Natural England's Risk and Issues Log - Deadline 1 Submission

The construction and operation of the Morgan Generation Offshore Wind Farm located approximately 37km from the Northwest English Coast in the Irish Sea.

Planning Inspectorate Reference [EN010136]

3rd October 2024

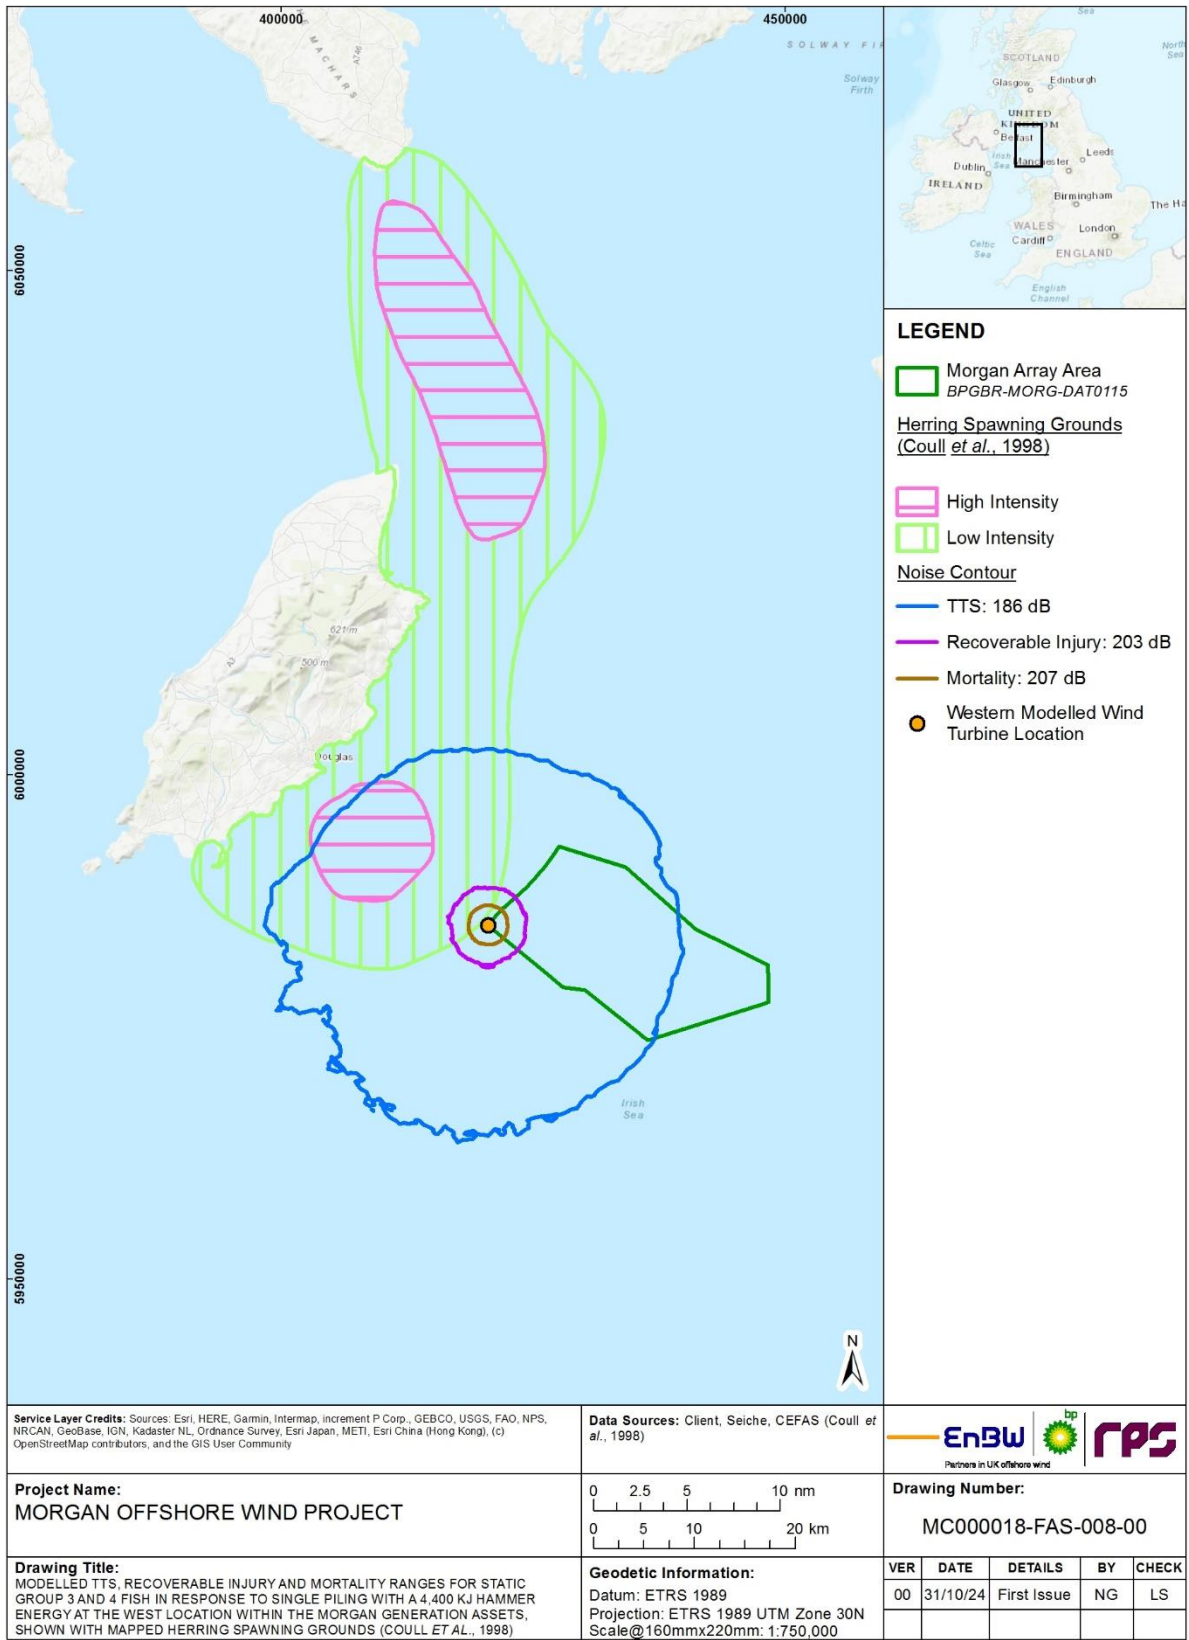
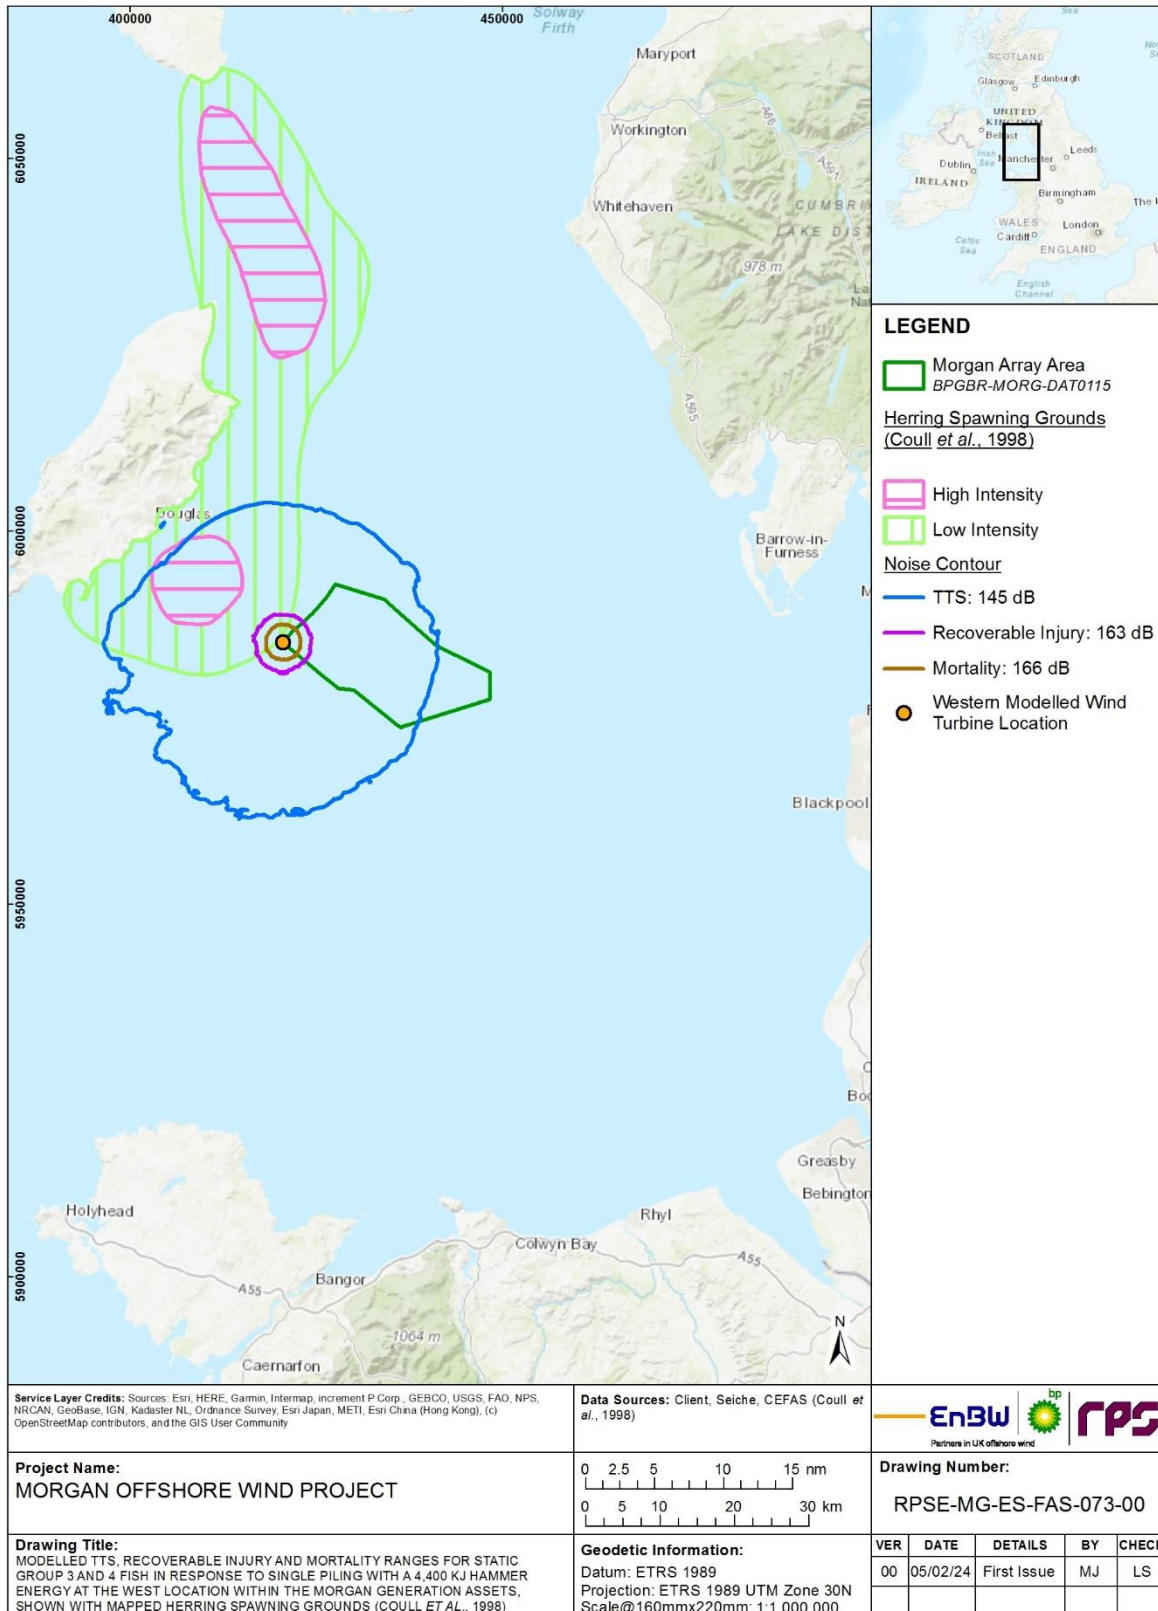
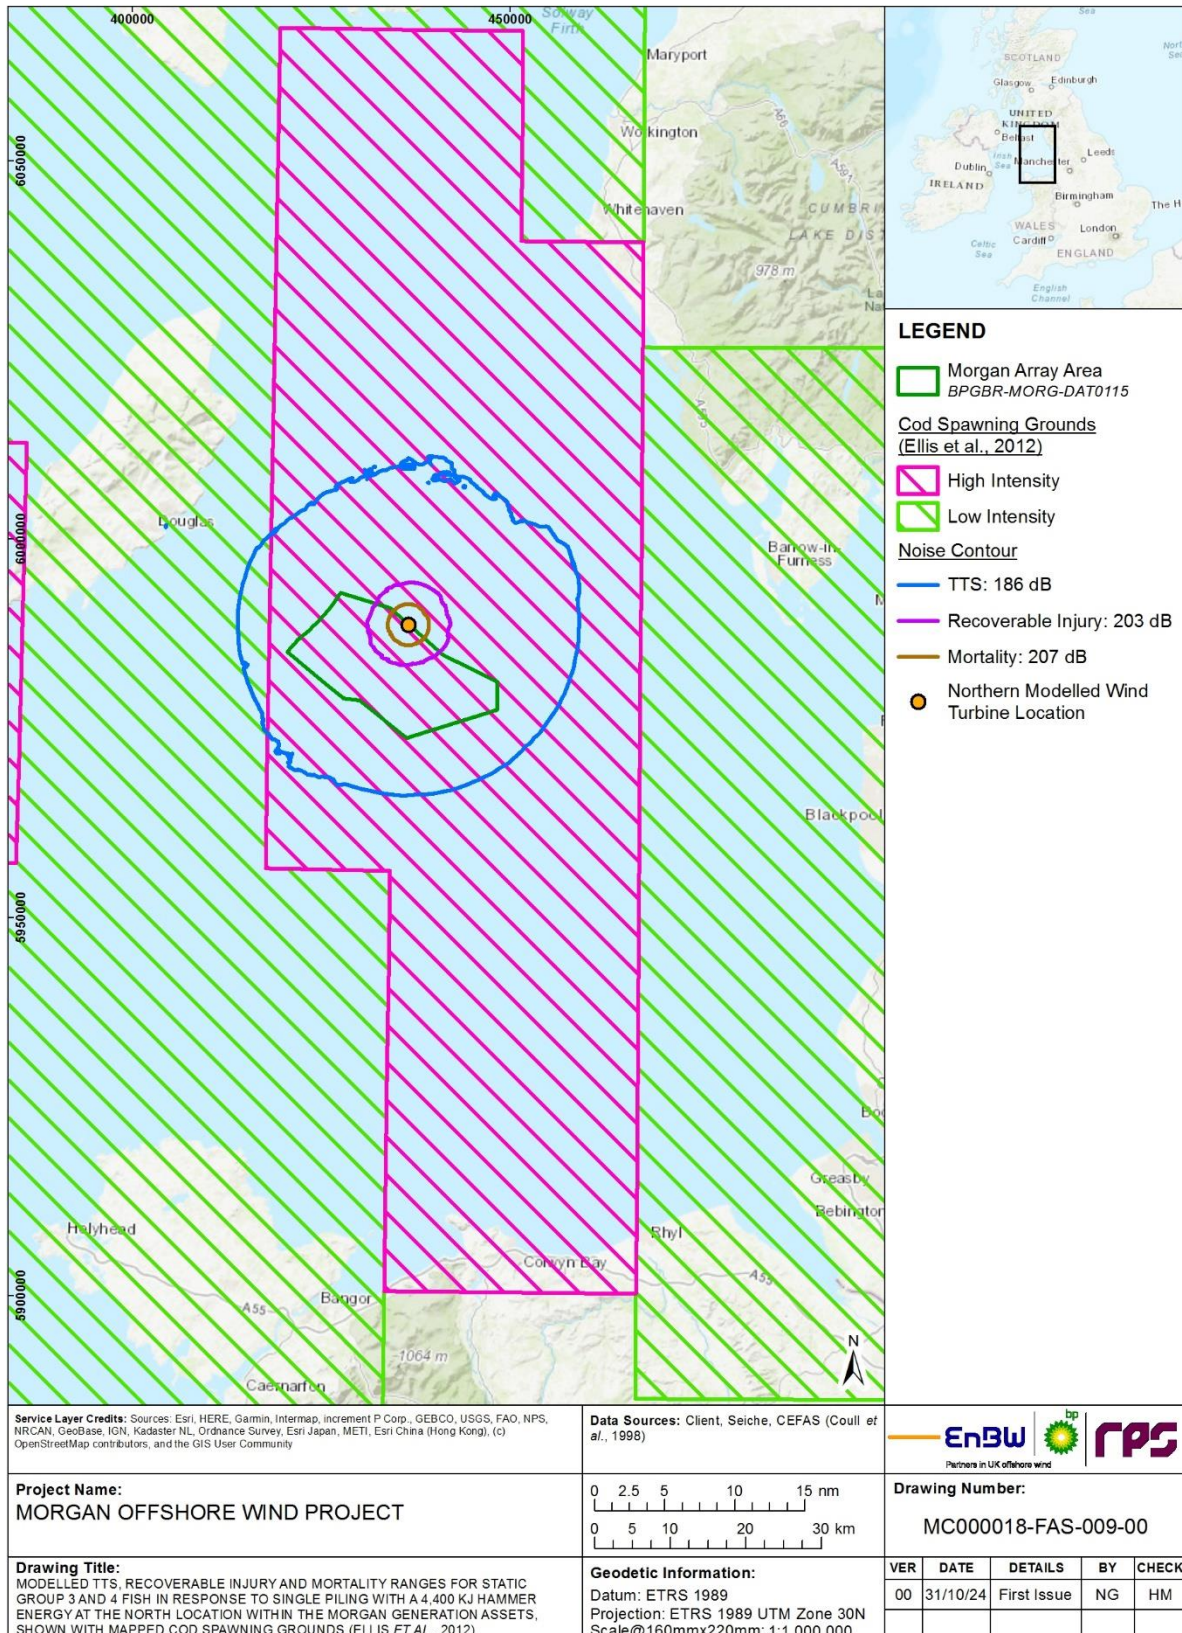
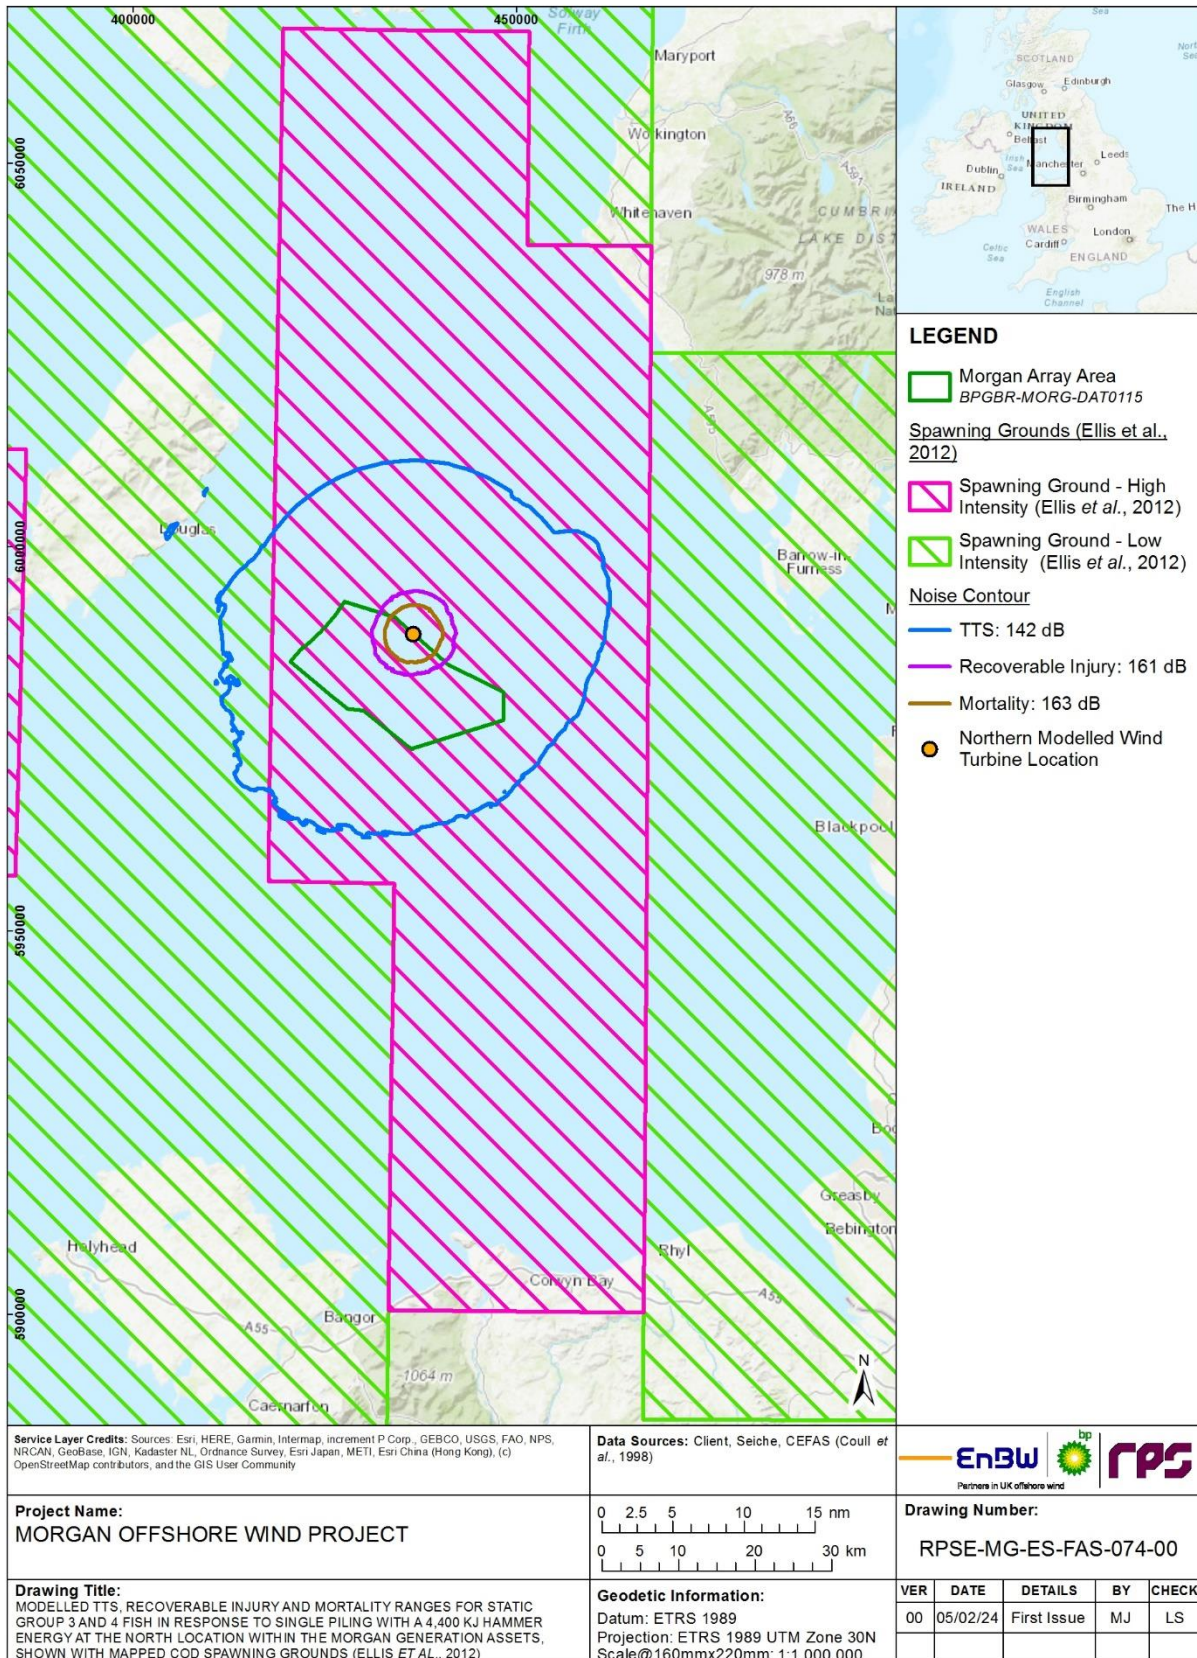
4	E7	Further to the above comment, whilst it is useful to display TTS range (23,900m) for fish in a tabular format, it would be more useful to have a site contour map displaying the array red line boundary, designated sites and this range to allow Natural England to visually assess proximity to protected sites more easily. Provide a contour map for TTS range.		Contour maps for TTS range have been provided by the Applicant. Comment resolved.
